Re: Sandia Foundation
807 Arno St NE
Traffic Circulation Layout
Engineer's 08-08-16 (J14D181)

RE: Lomas / Broadway Parking Improvements Submittal 2

RESPEC is requesting a second review of the Traffic Circulation Layout at the northeast corner of Lomas Blvd. and Broadway Blvd. Previously, the address for submittal used was 807 Arno St. NE, Albuquerque NM 87102. This address is incorrect, and the correct address should be the following: 800 Broadway Blvd. NE Apt A/B, Albuquerque, NM 87102. The legal description for this plat is Tract 2-A, Lands of Sandia Foundation.

TRACT 2-A (1.3642 AC.)
 LANDS OF SANDIA FOUNDATION
 807 ARNO ST., NE. ABOQ NM 87102
 TRAFFIC CIRCULATION LAYOUT
 GRADING / DRAINAGE

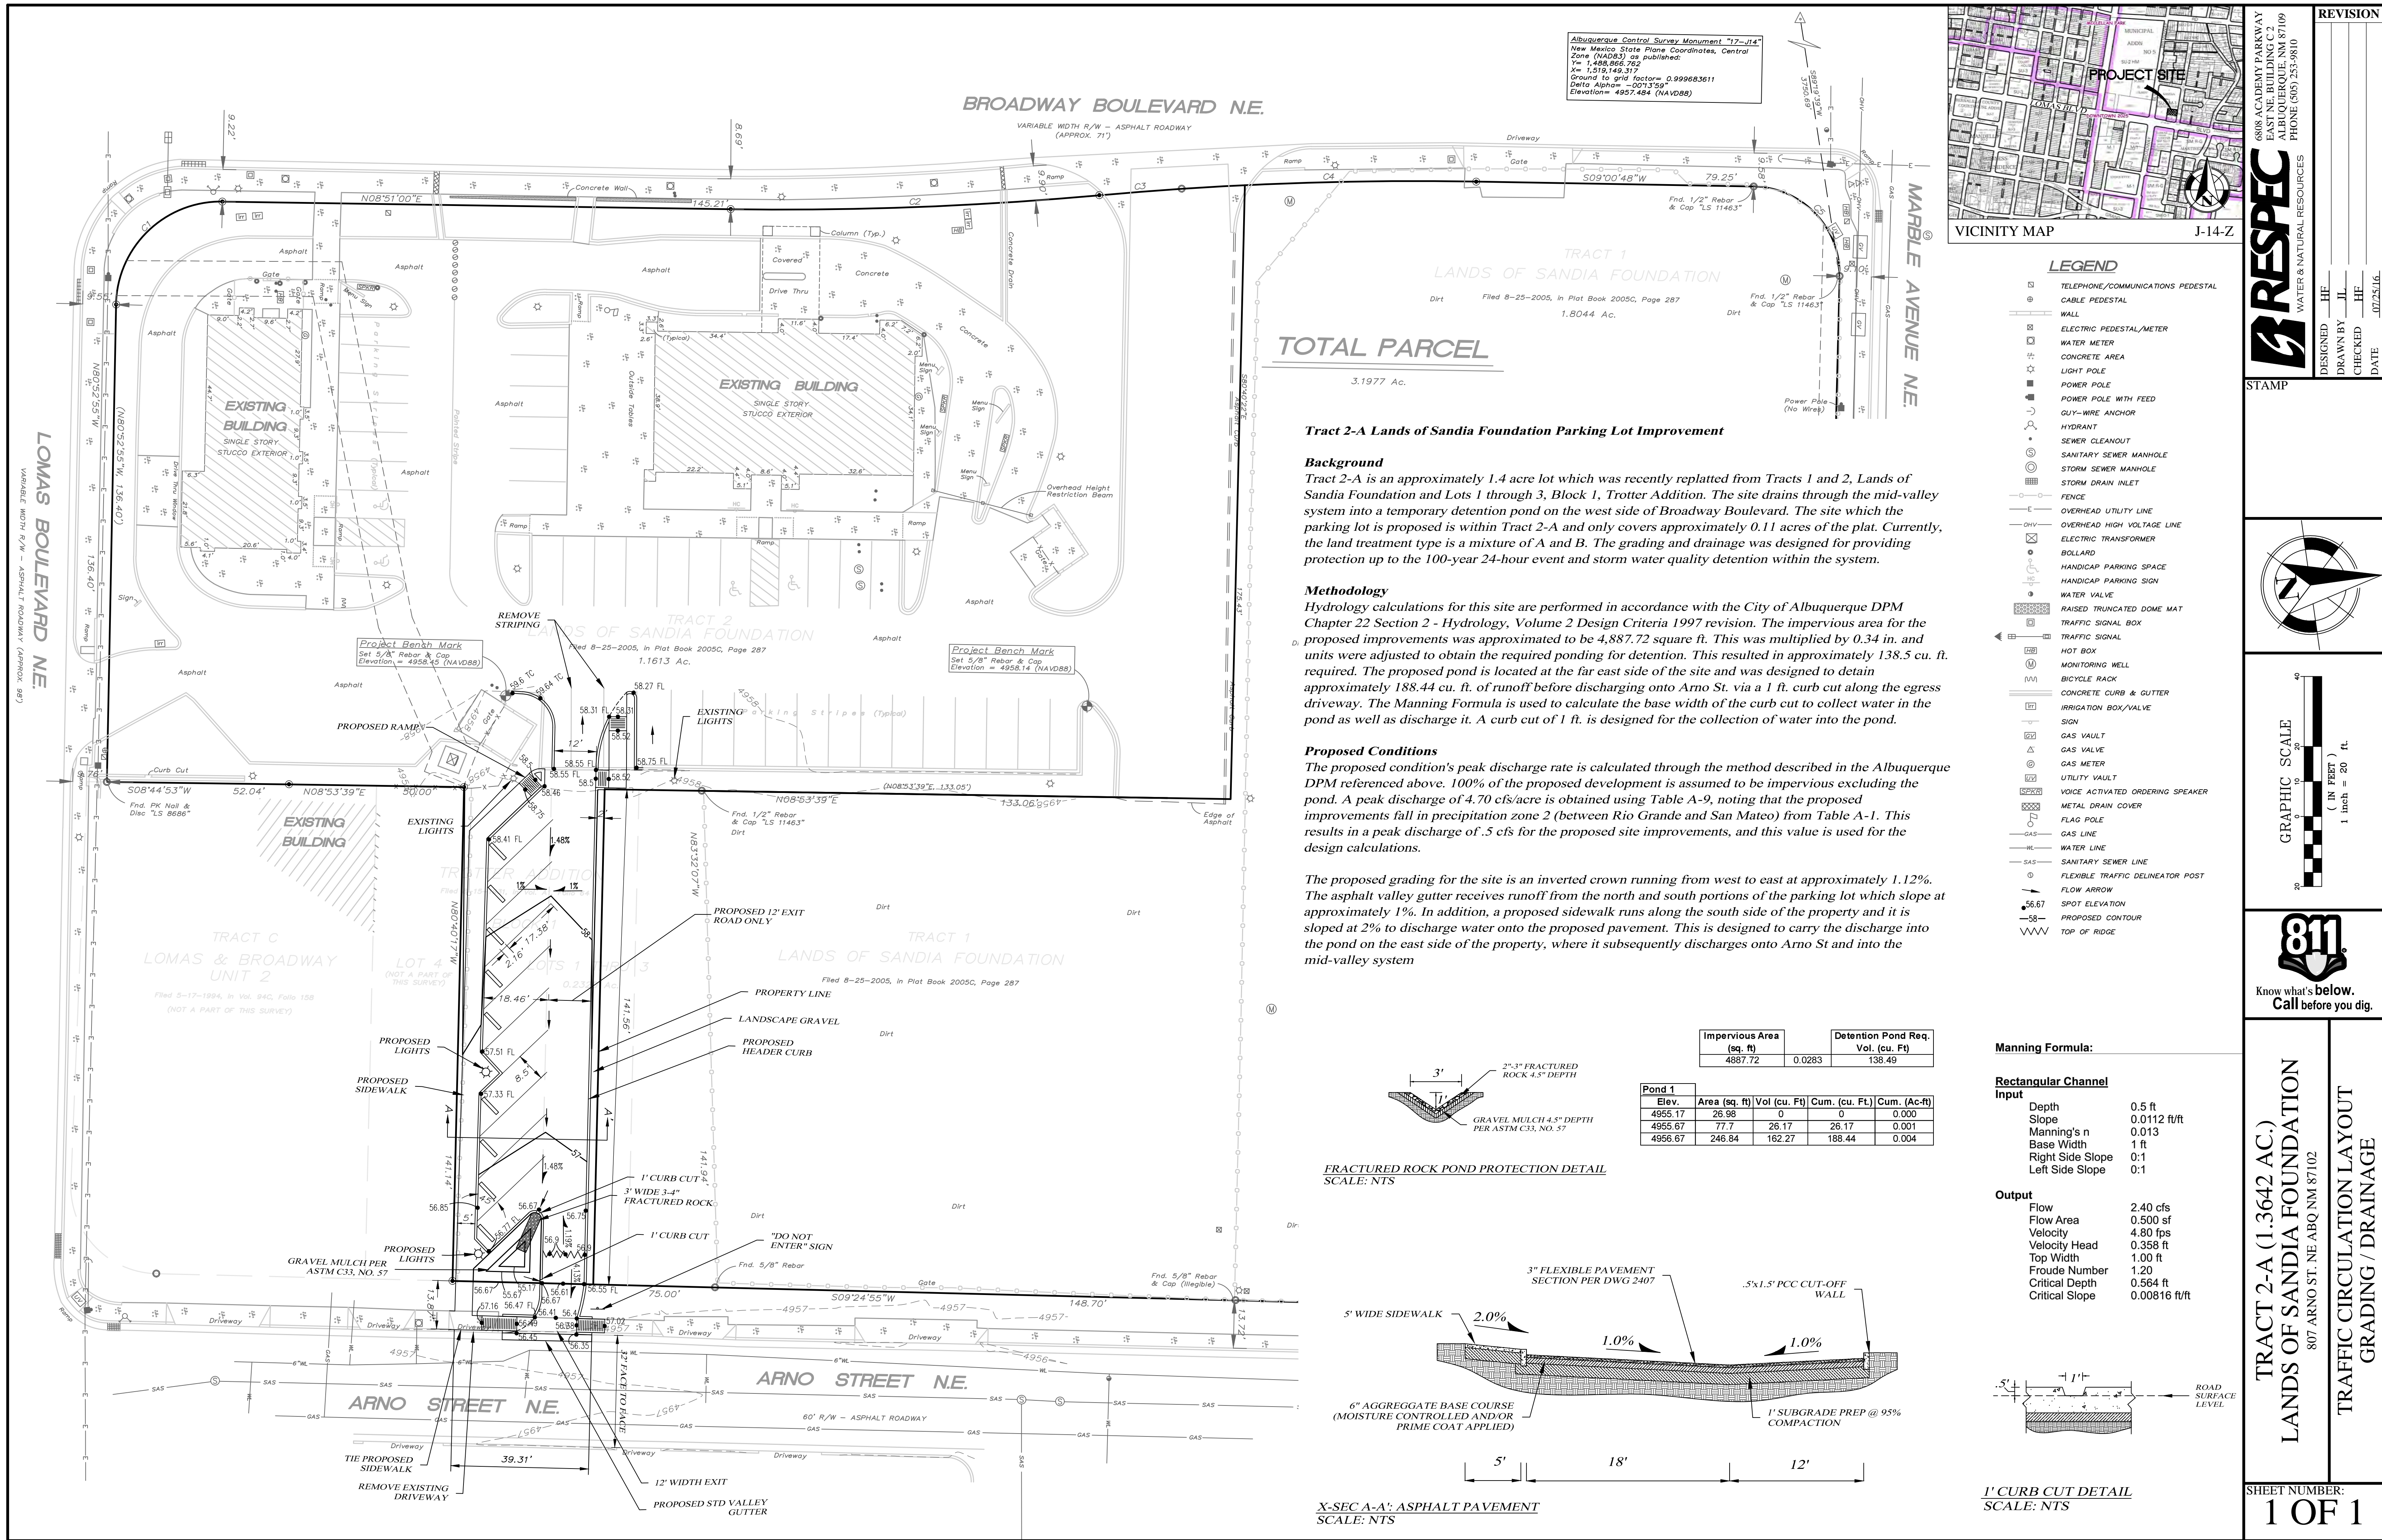
1. Show all drive aisle widths and radii of end islands.
 - 12' drive aisle width is in plan at the entrance of parking lot and mid parking lot.
2. One way vehicular paths require pavement directional signage and a posted "Do Not Enter" sign at the point of egress. Please show detail and location of posted signs.

- "Do Not Enter" sign location is at the egress of lot and a detail has been added to the plan.
3. Please specify the City Standard Drawing Number when applicable.

- Drawing numbers have been added to plans where necessary.
4. Unused curb cuts must be replaced with sidewalk and curb & gutter. A build note must be provided referring to the appropriate City Standard drawing.

5. A gutter at the East drive way is not necessary unless required by Hydrology.
 - Proposed gutter removed, to be addressed after Hydrology review.
6. Please include two copies of the traffic circulation layout at the next submittal.

- Callout details near the driveway at the west side of the lot have been cleaned up. The callouts now show where the proposed sidewalk ties to existing and to remove the driveway and replace with sidewalk, curb, and gutter per standard drawings.
